13 August 2015

YASS VALLEY WIND FARM REMOVAL OF TRANSMISSION CORRIDOR OPTION

Attachment: Removal of Eastern Corridor

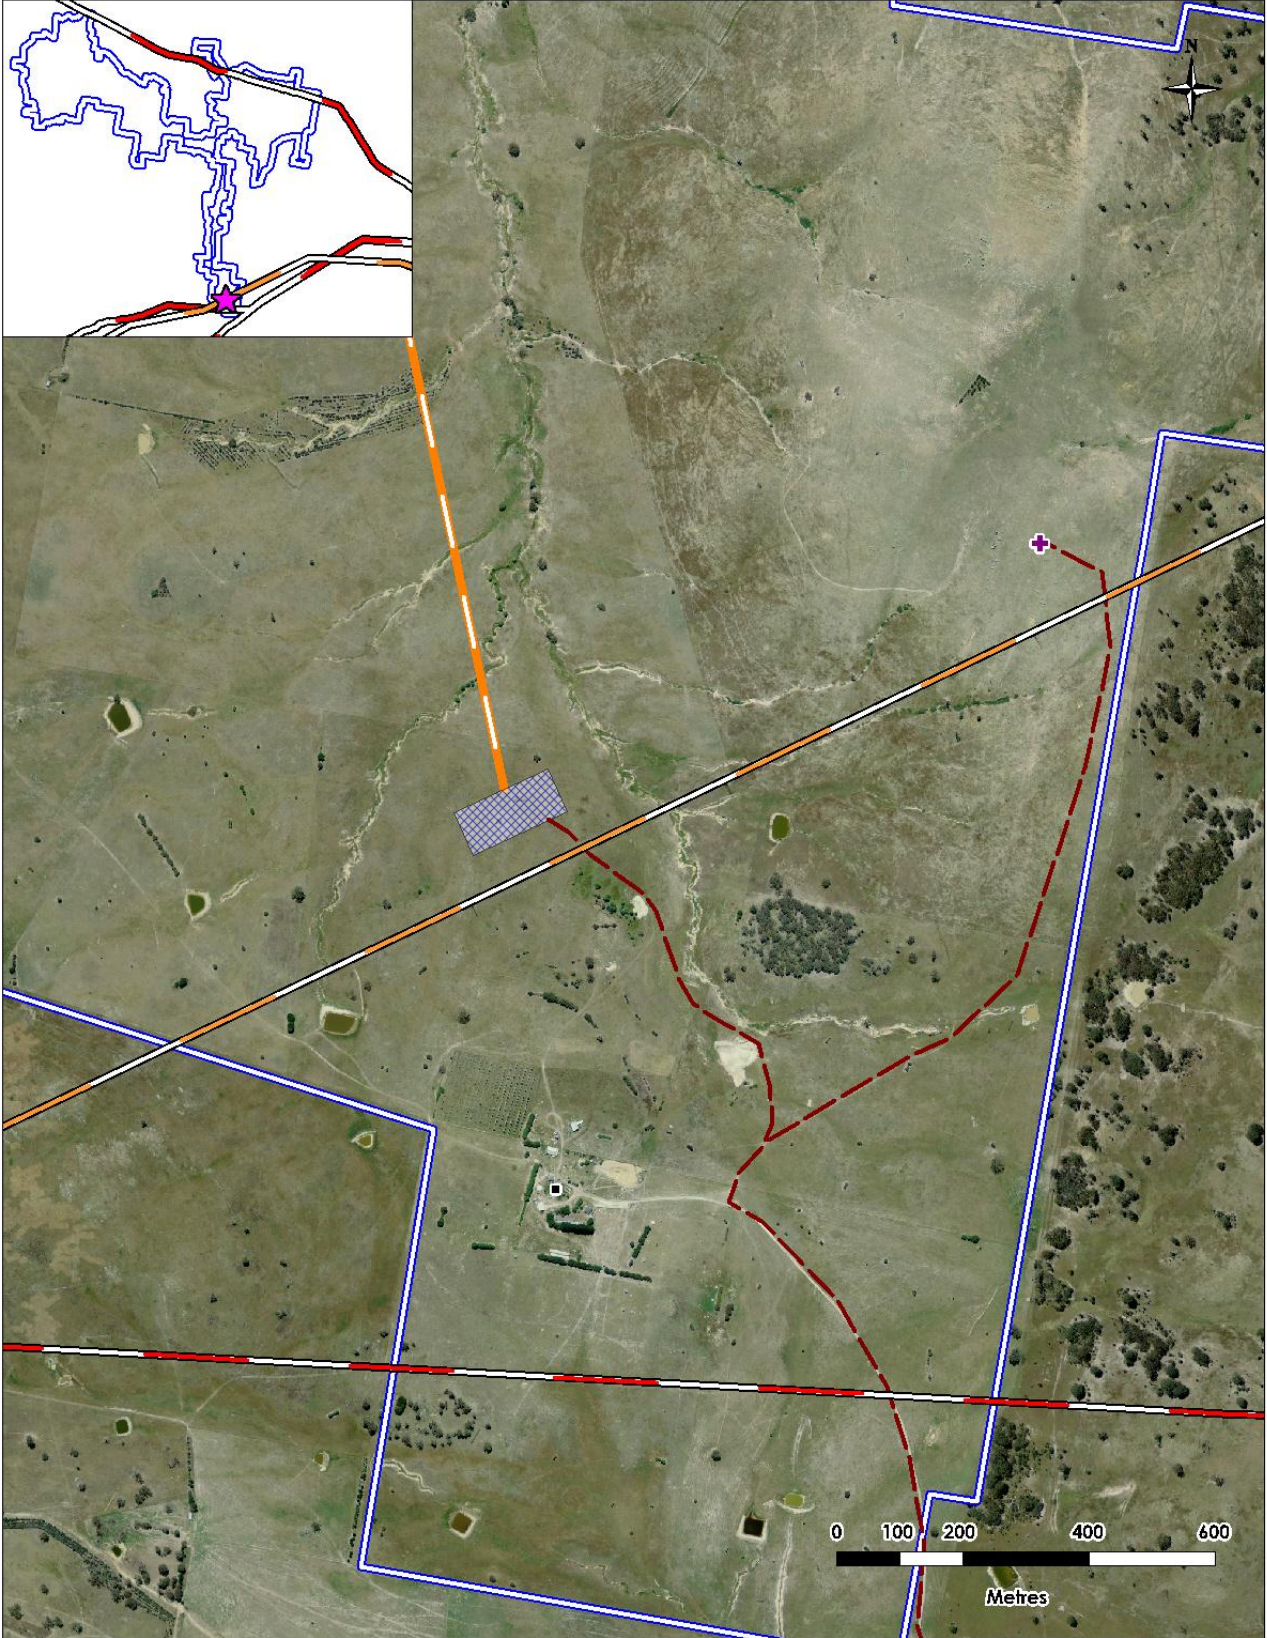
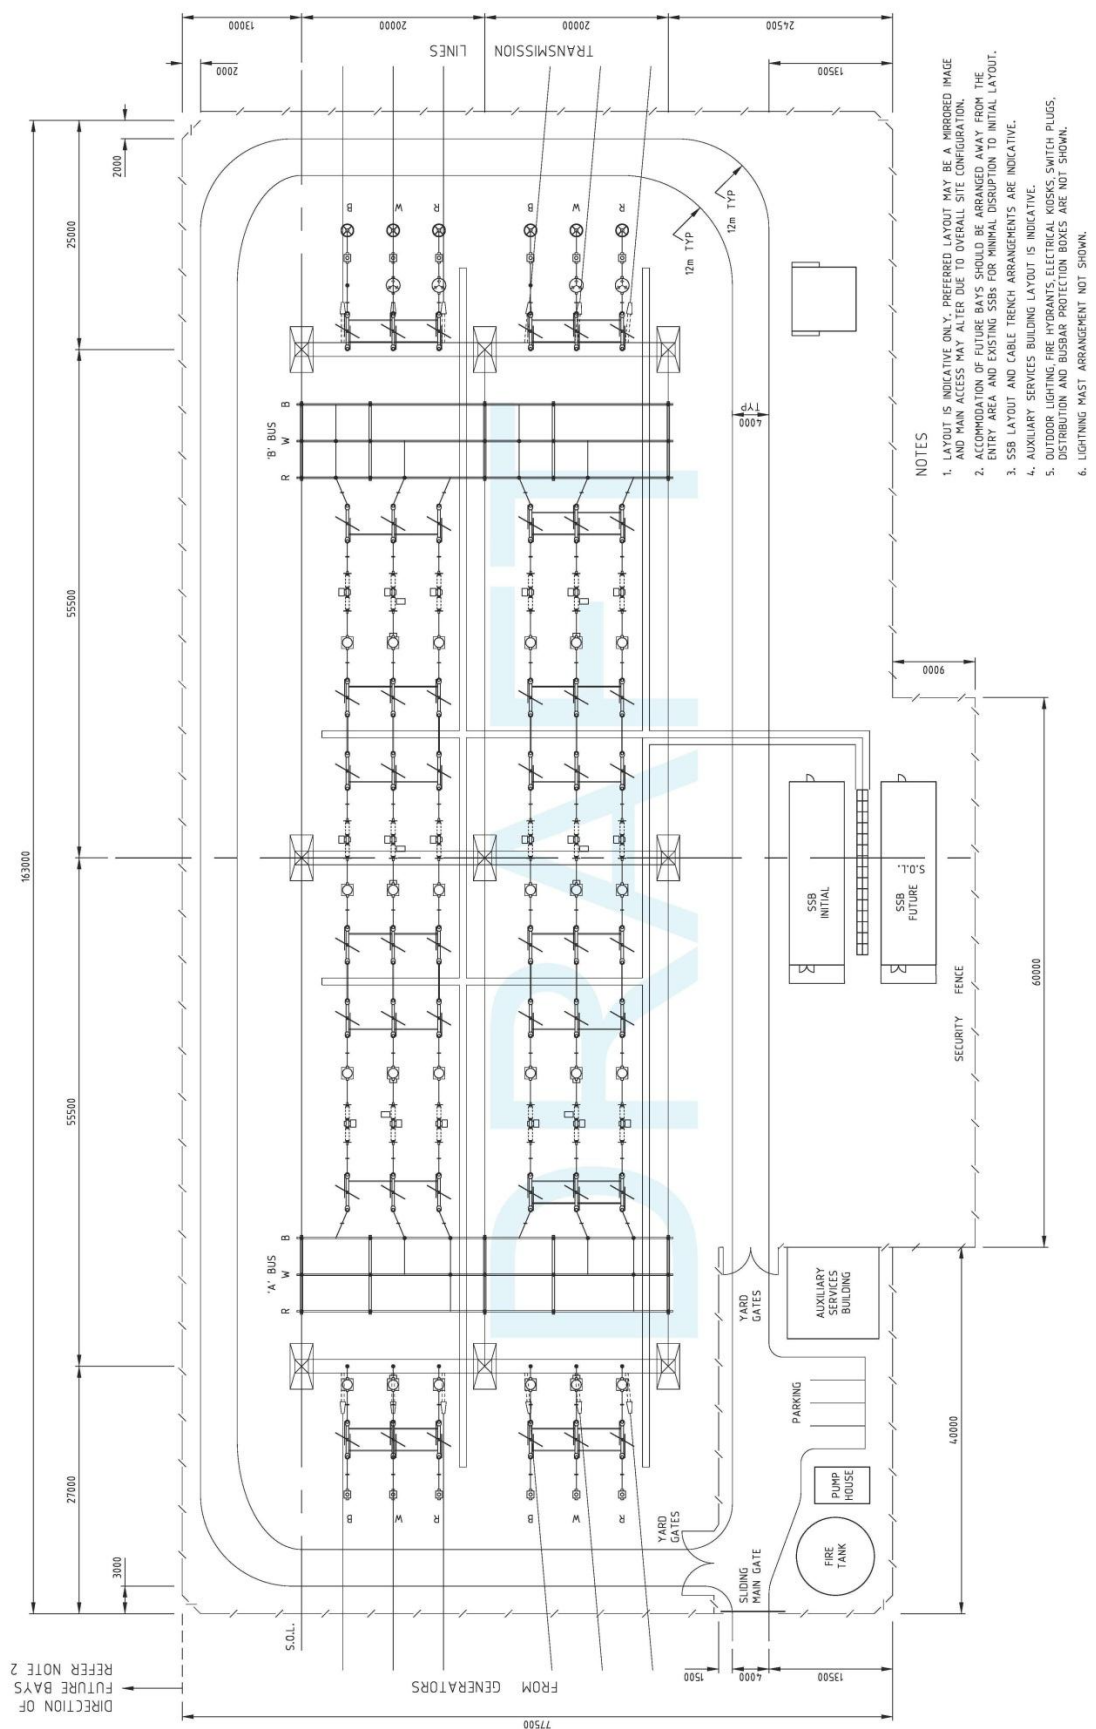
As a result of this review, Epuron has decided to remove the eastern-most grid connection corridor (and associated Infrastructure Envelope) as outlined in the attached map. This corridor provided an alternate connection option which is no longer required; removal of this corridor does not in any way impact the constructability of the remainder of the project.

Note, the following map is based on the map titled *Final Project Layout with Project Envelope* (dated 21/05/15) provided to the Department on 24 June 2015. Indicated below in black and white are the switchyard, powerline and infrastructure envelope which Epuron proposes to remove from the development. All other infrastructure and development envelopes remain as outlined on the previous map.

- reduce impacts which would result from the construction of this corridor without any increase in impacts elsewhere on the site, and therefore result in a net environmental benefit;
- in particular, reduce visual impacts at dwellings in the vicinity of this connection corridor – we note the nearest dwellings are referenced G11, G12, G13, G14, G18, G36, G38, G39 and M8; and,
- increase certainty as to the likely grid connection corridor to be used.
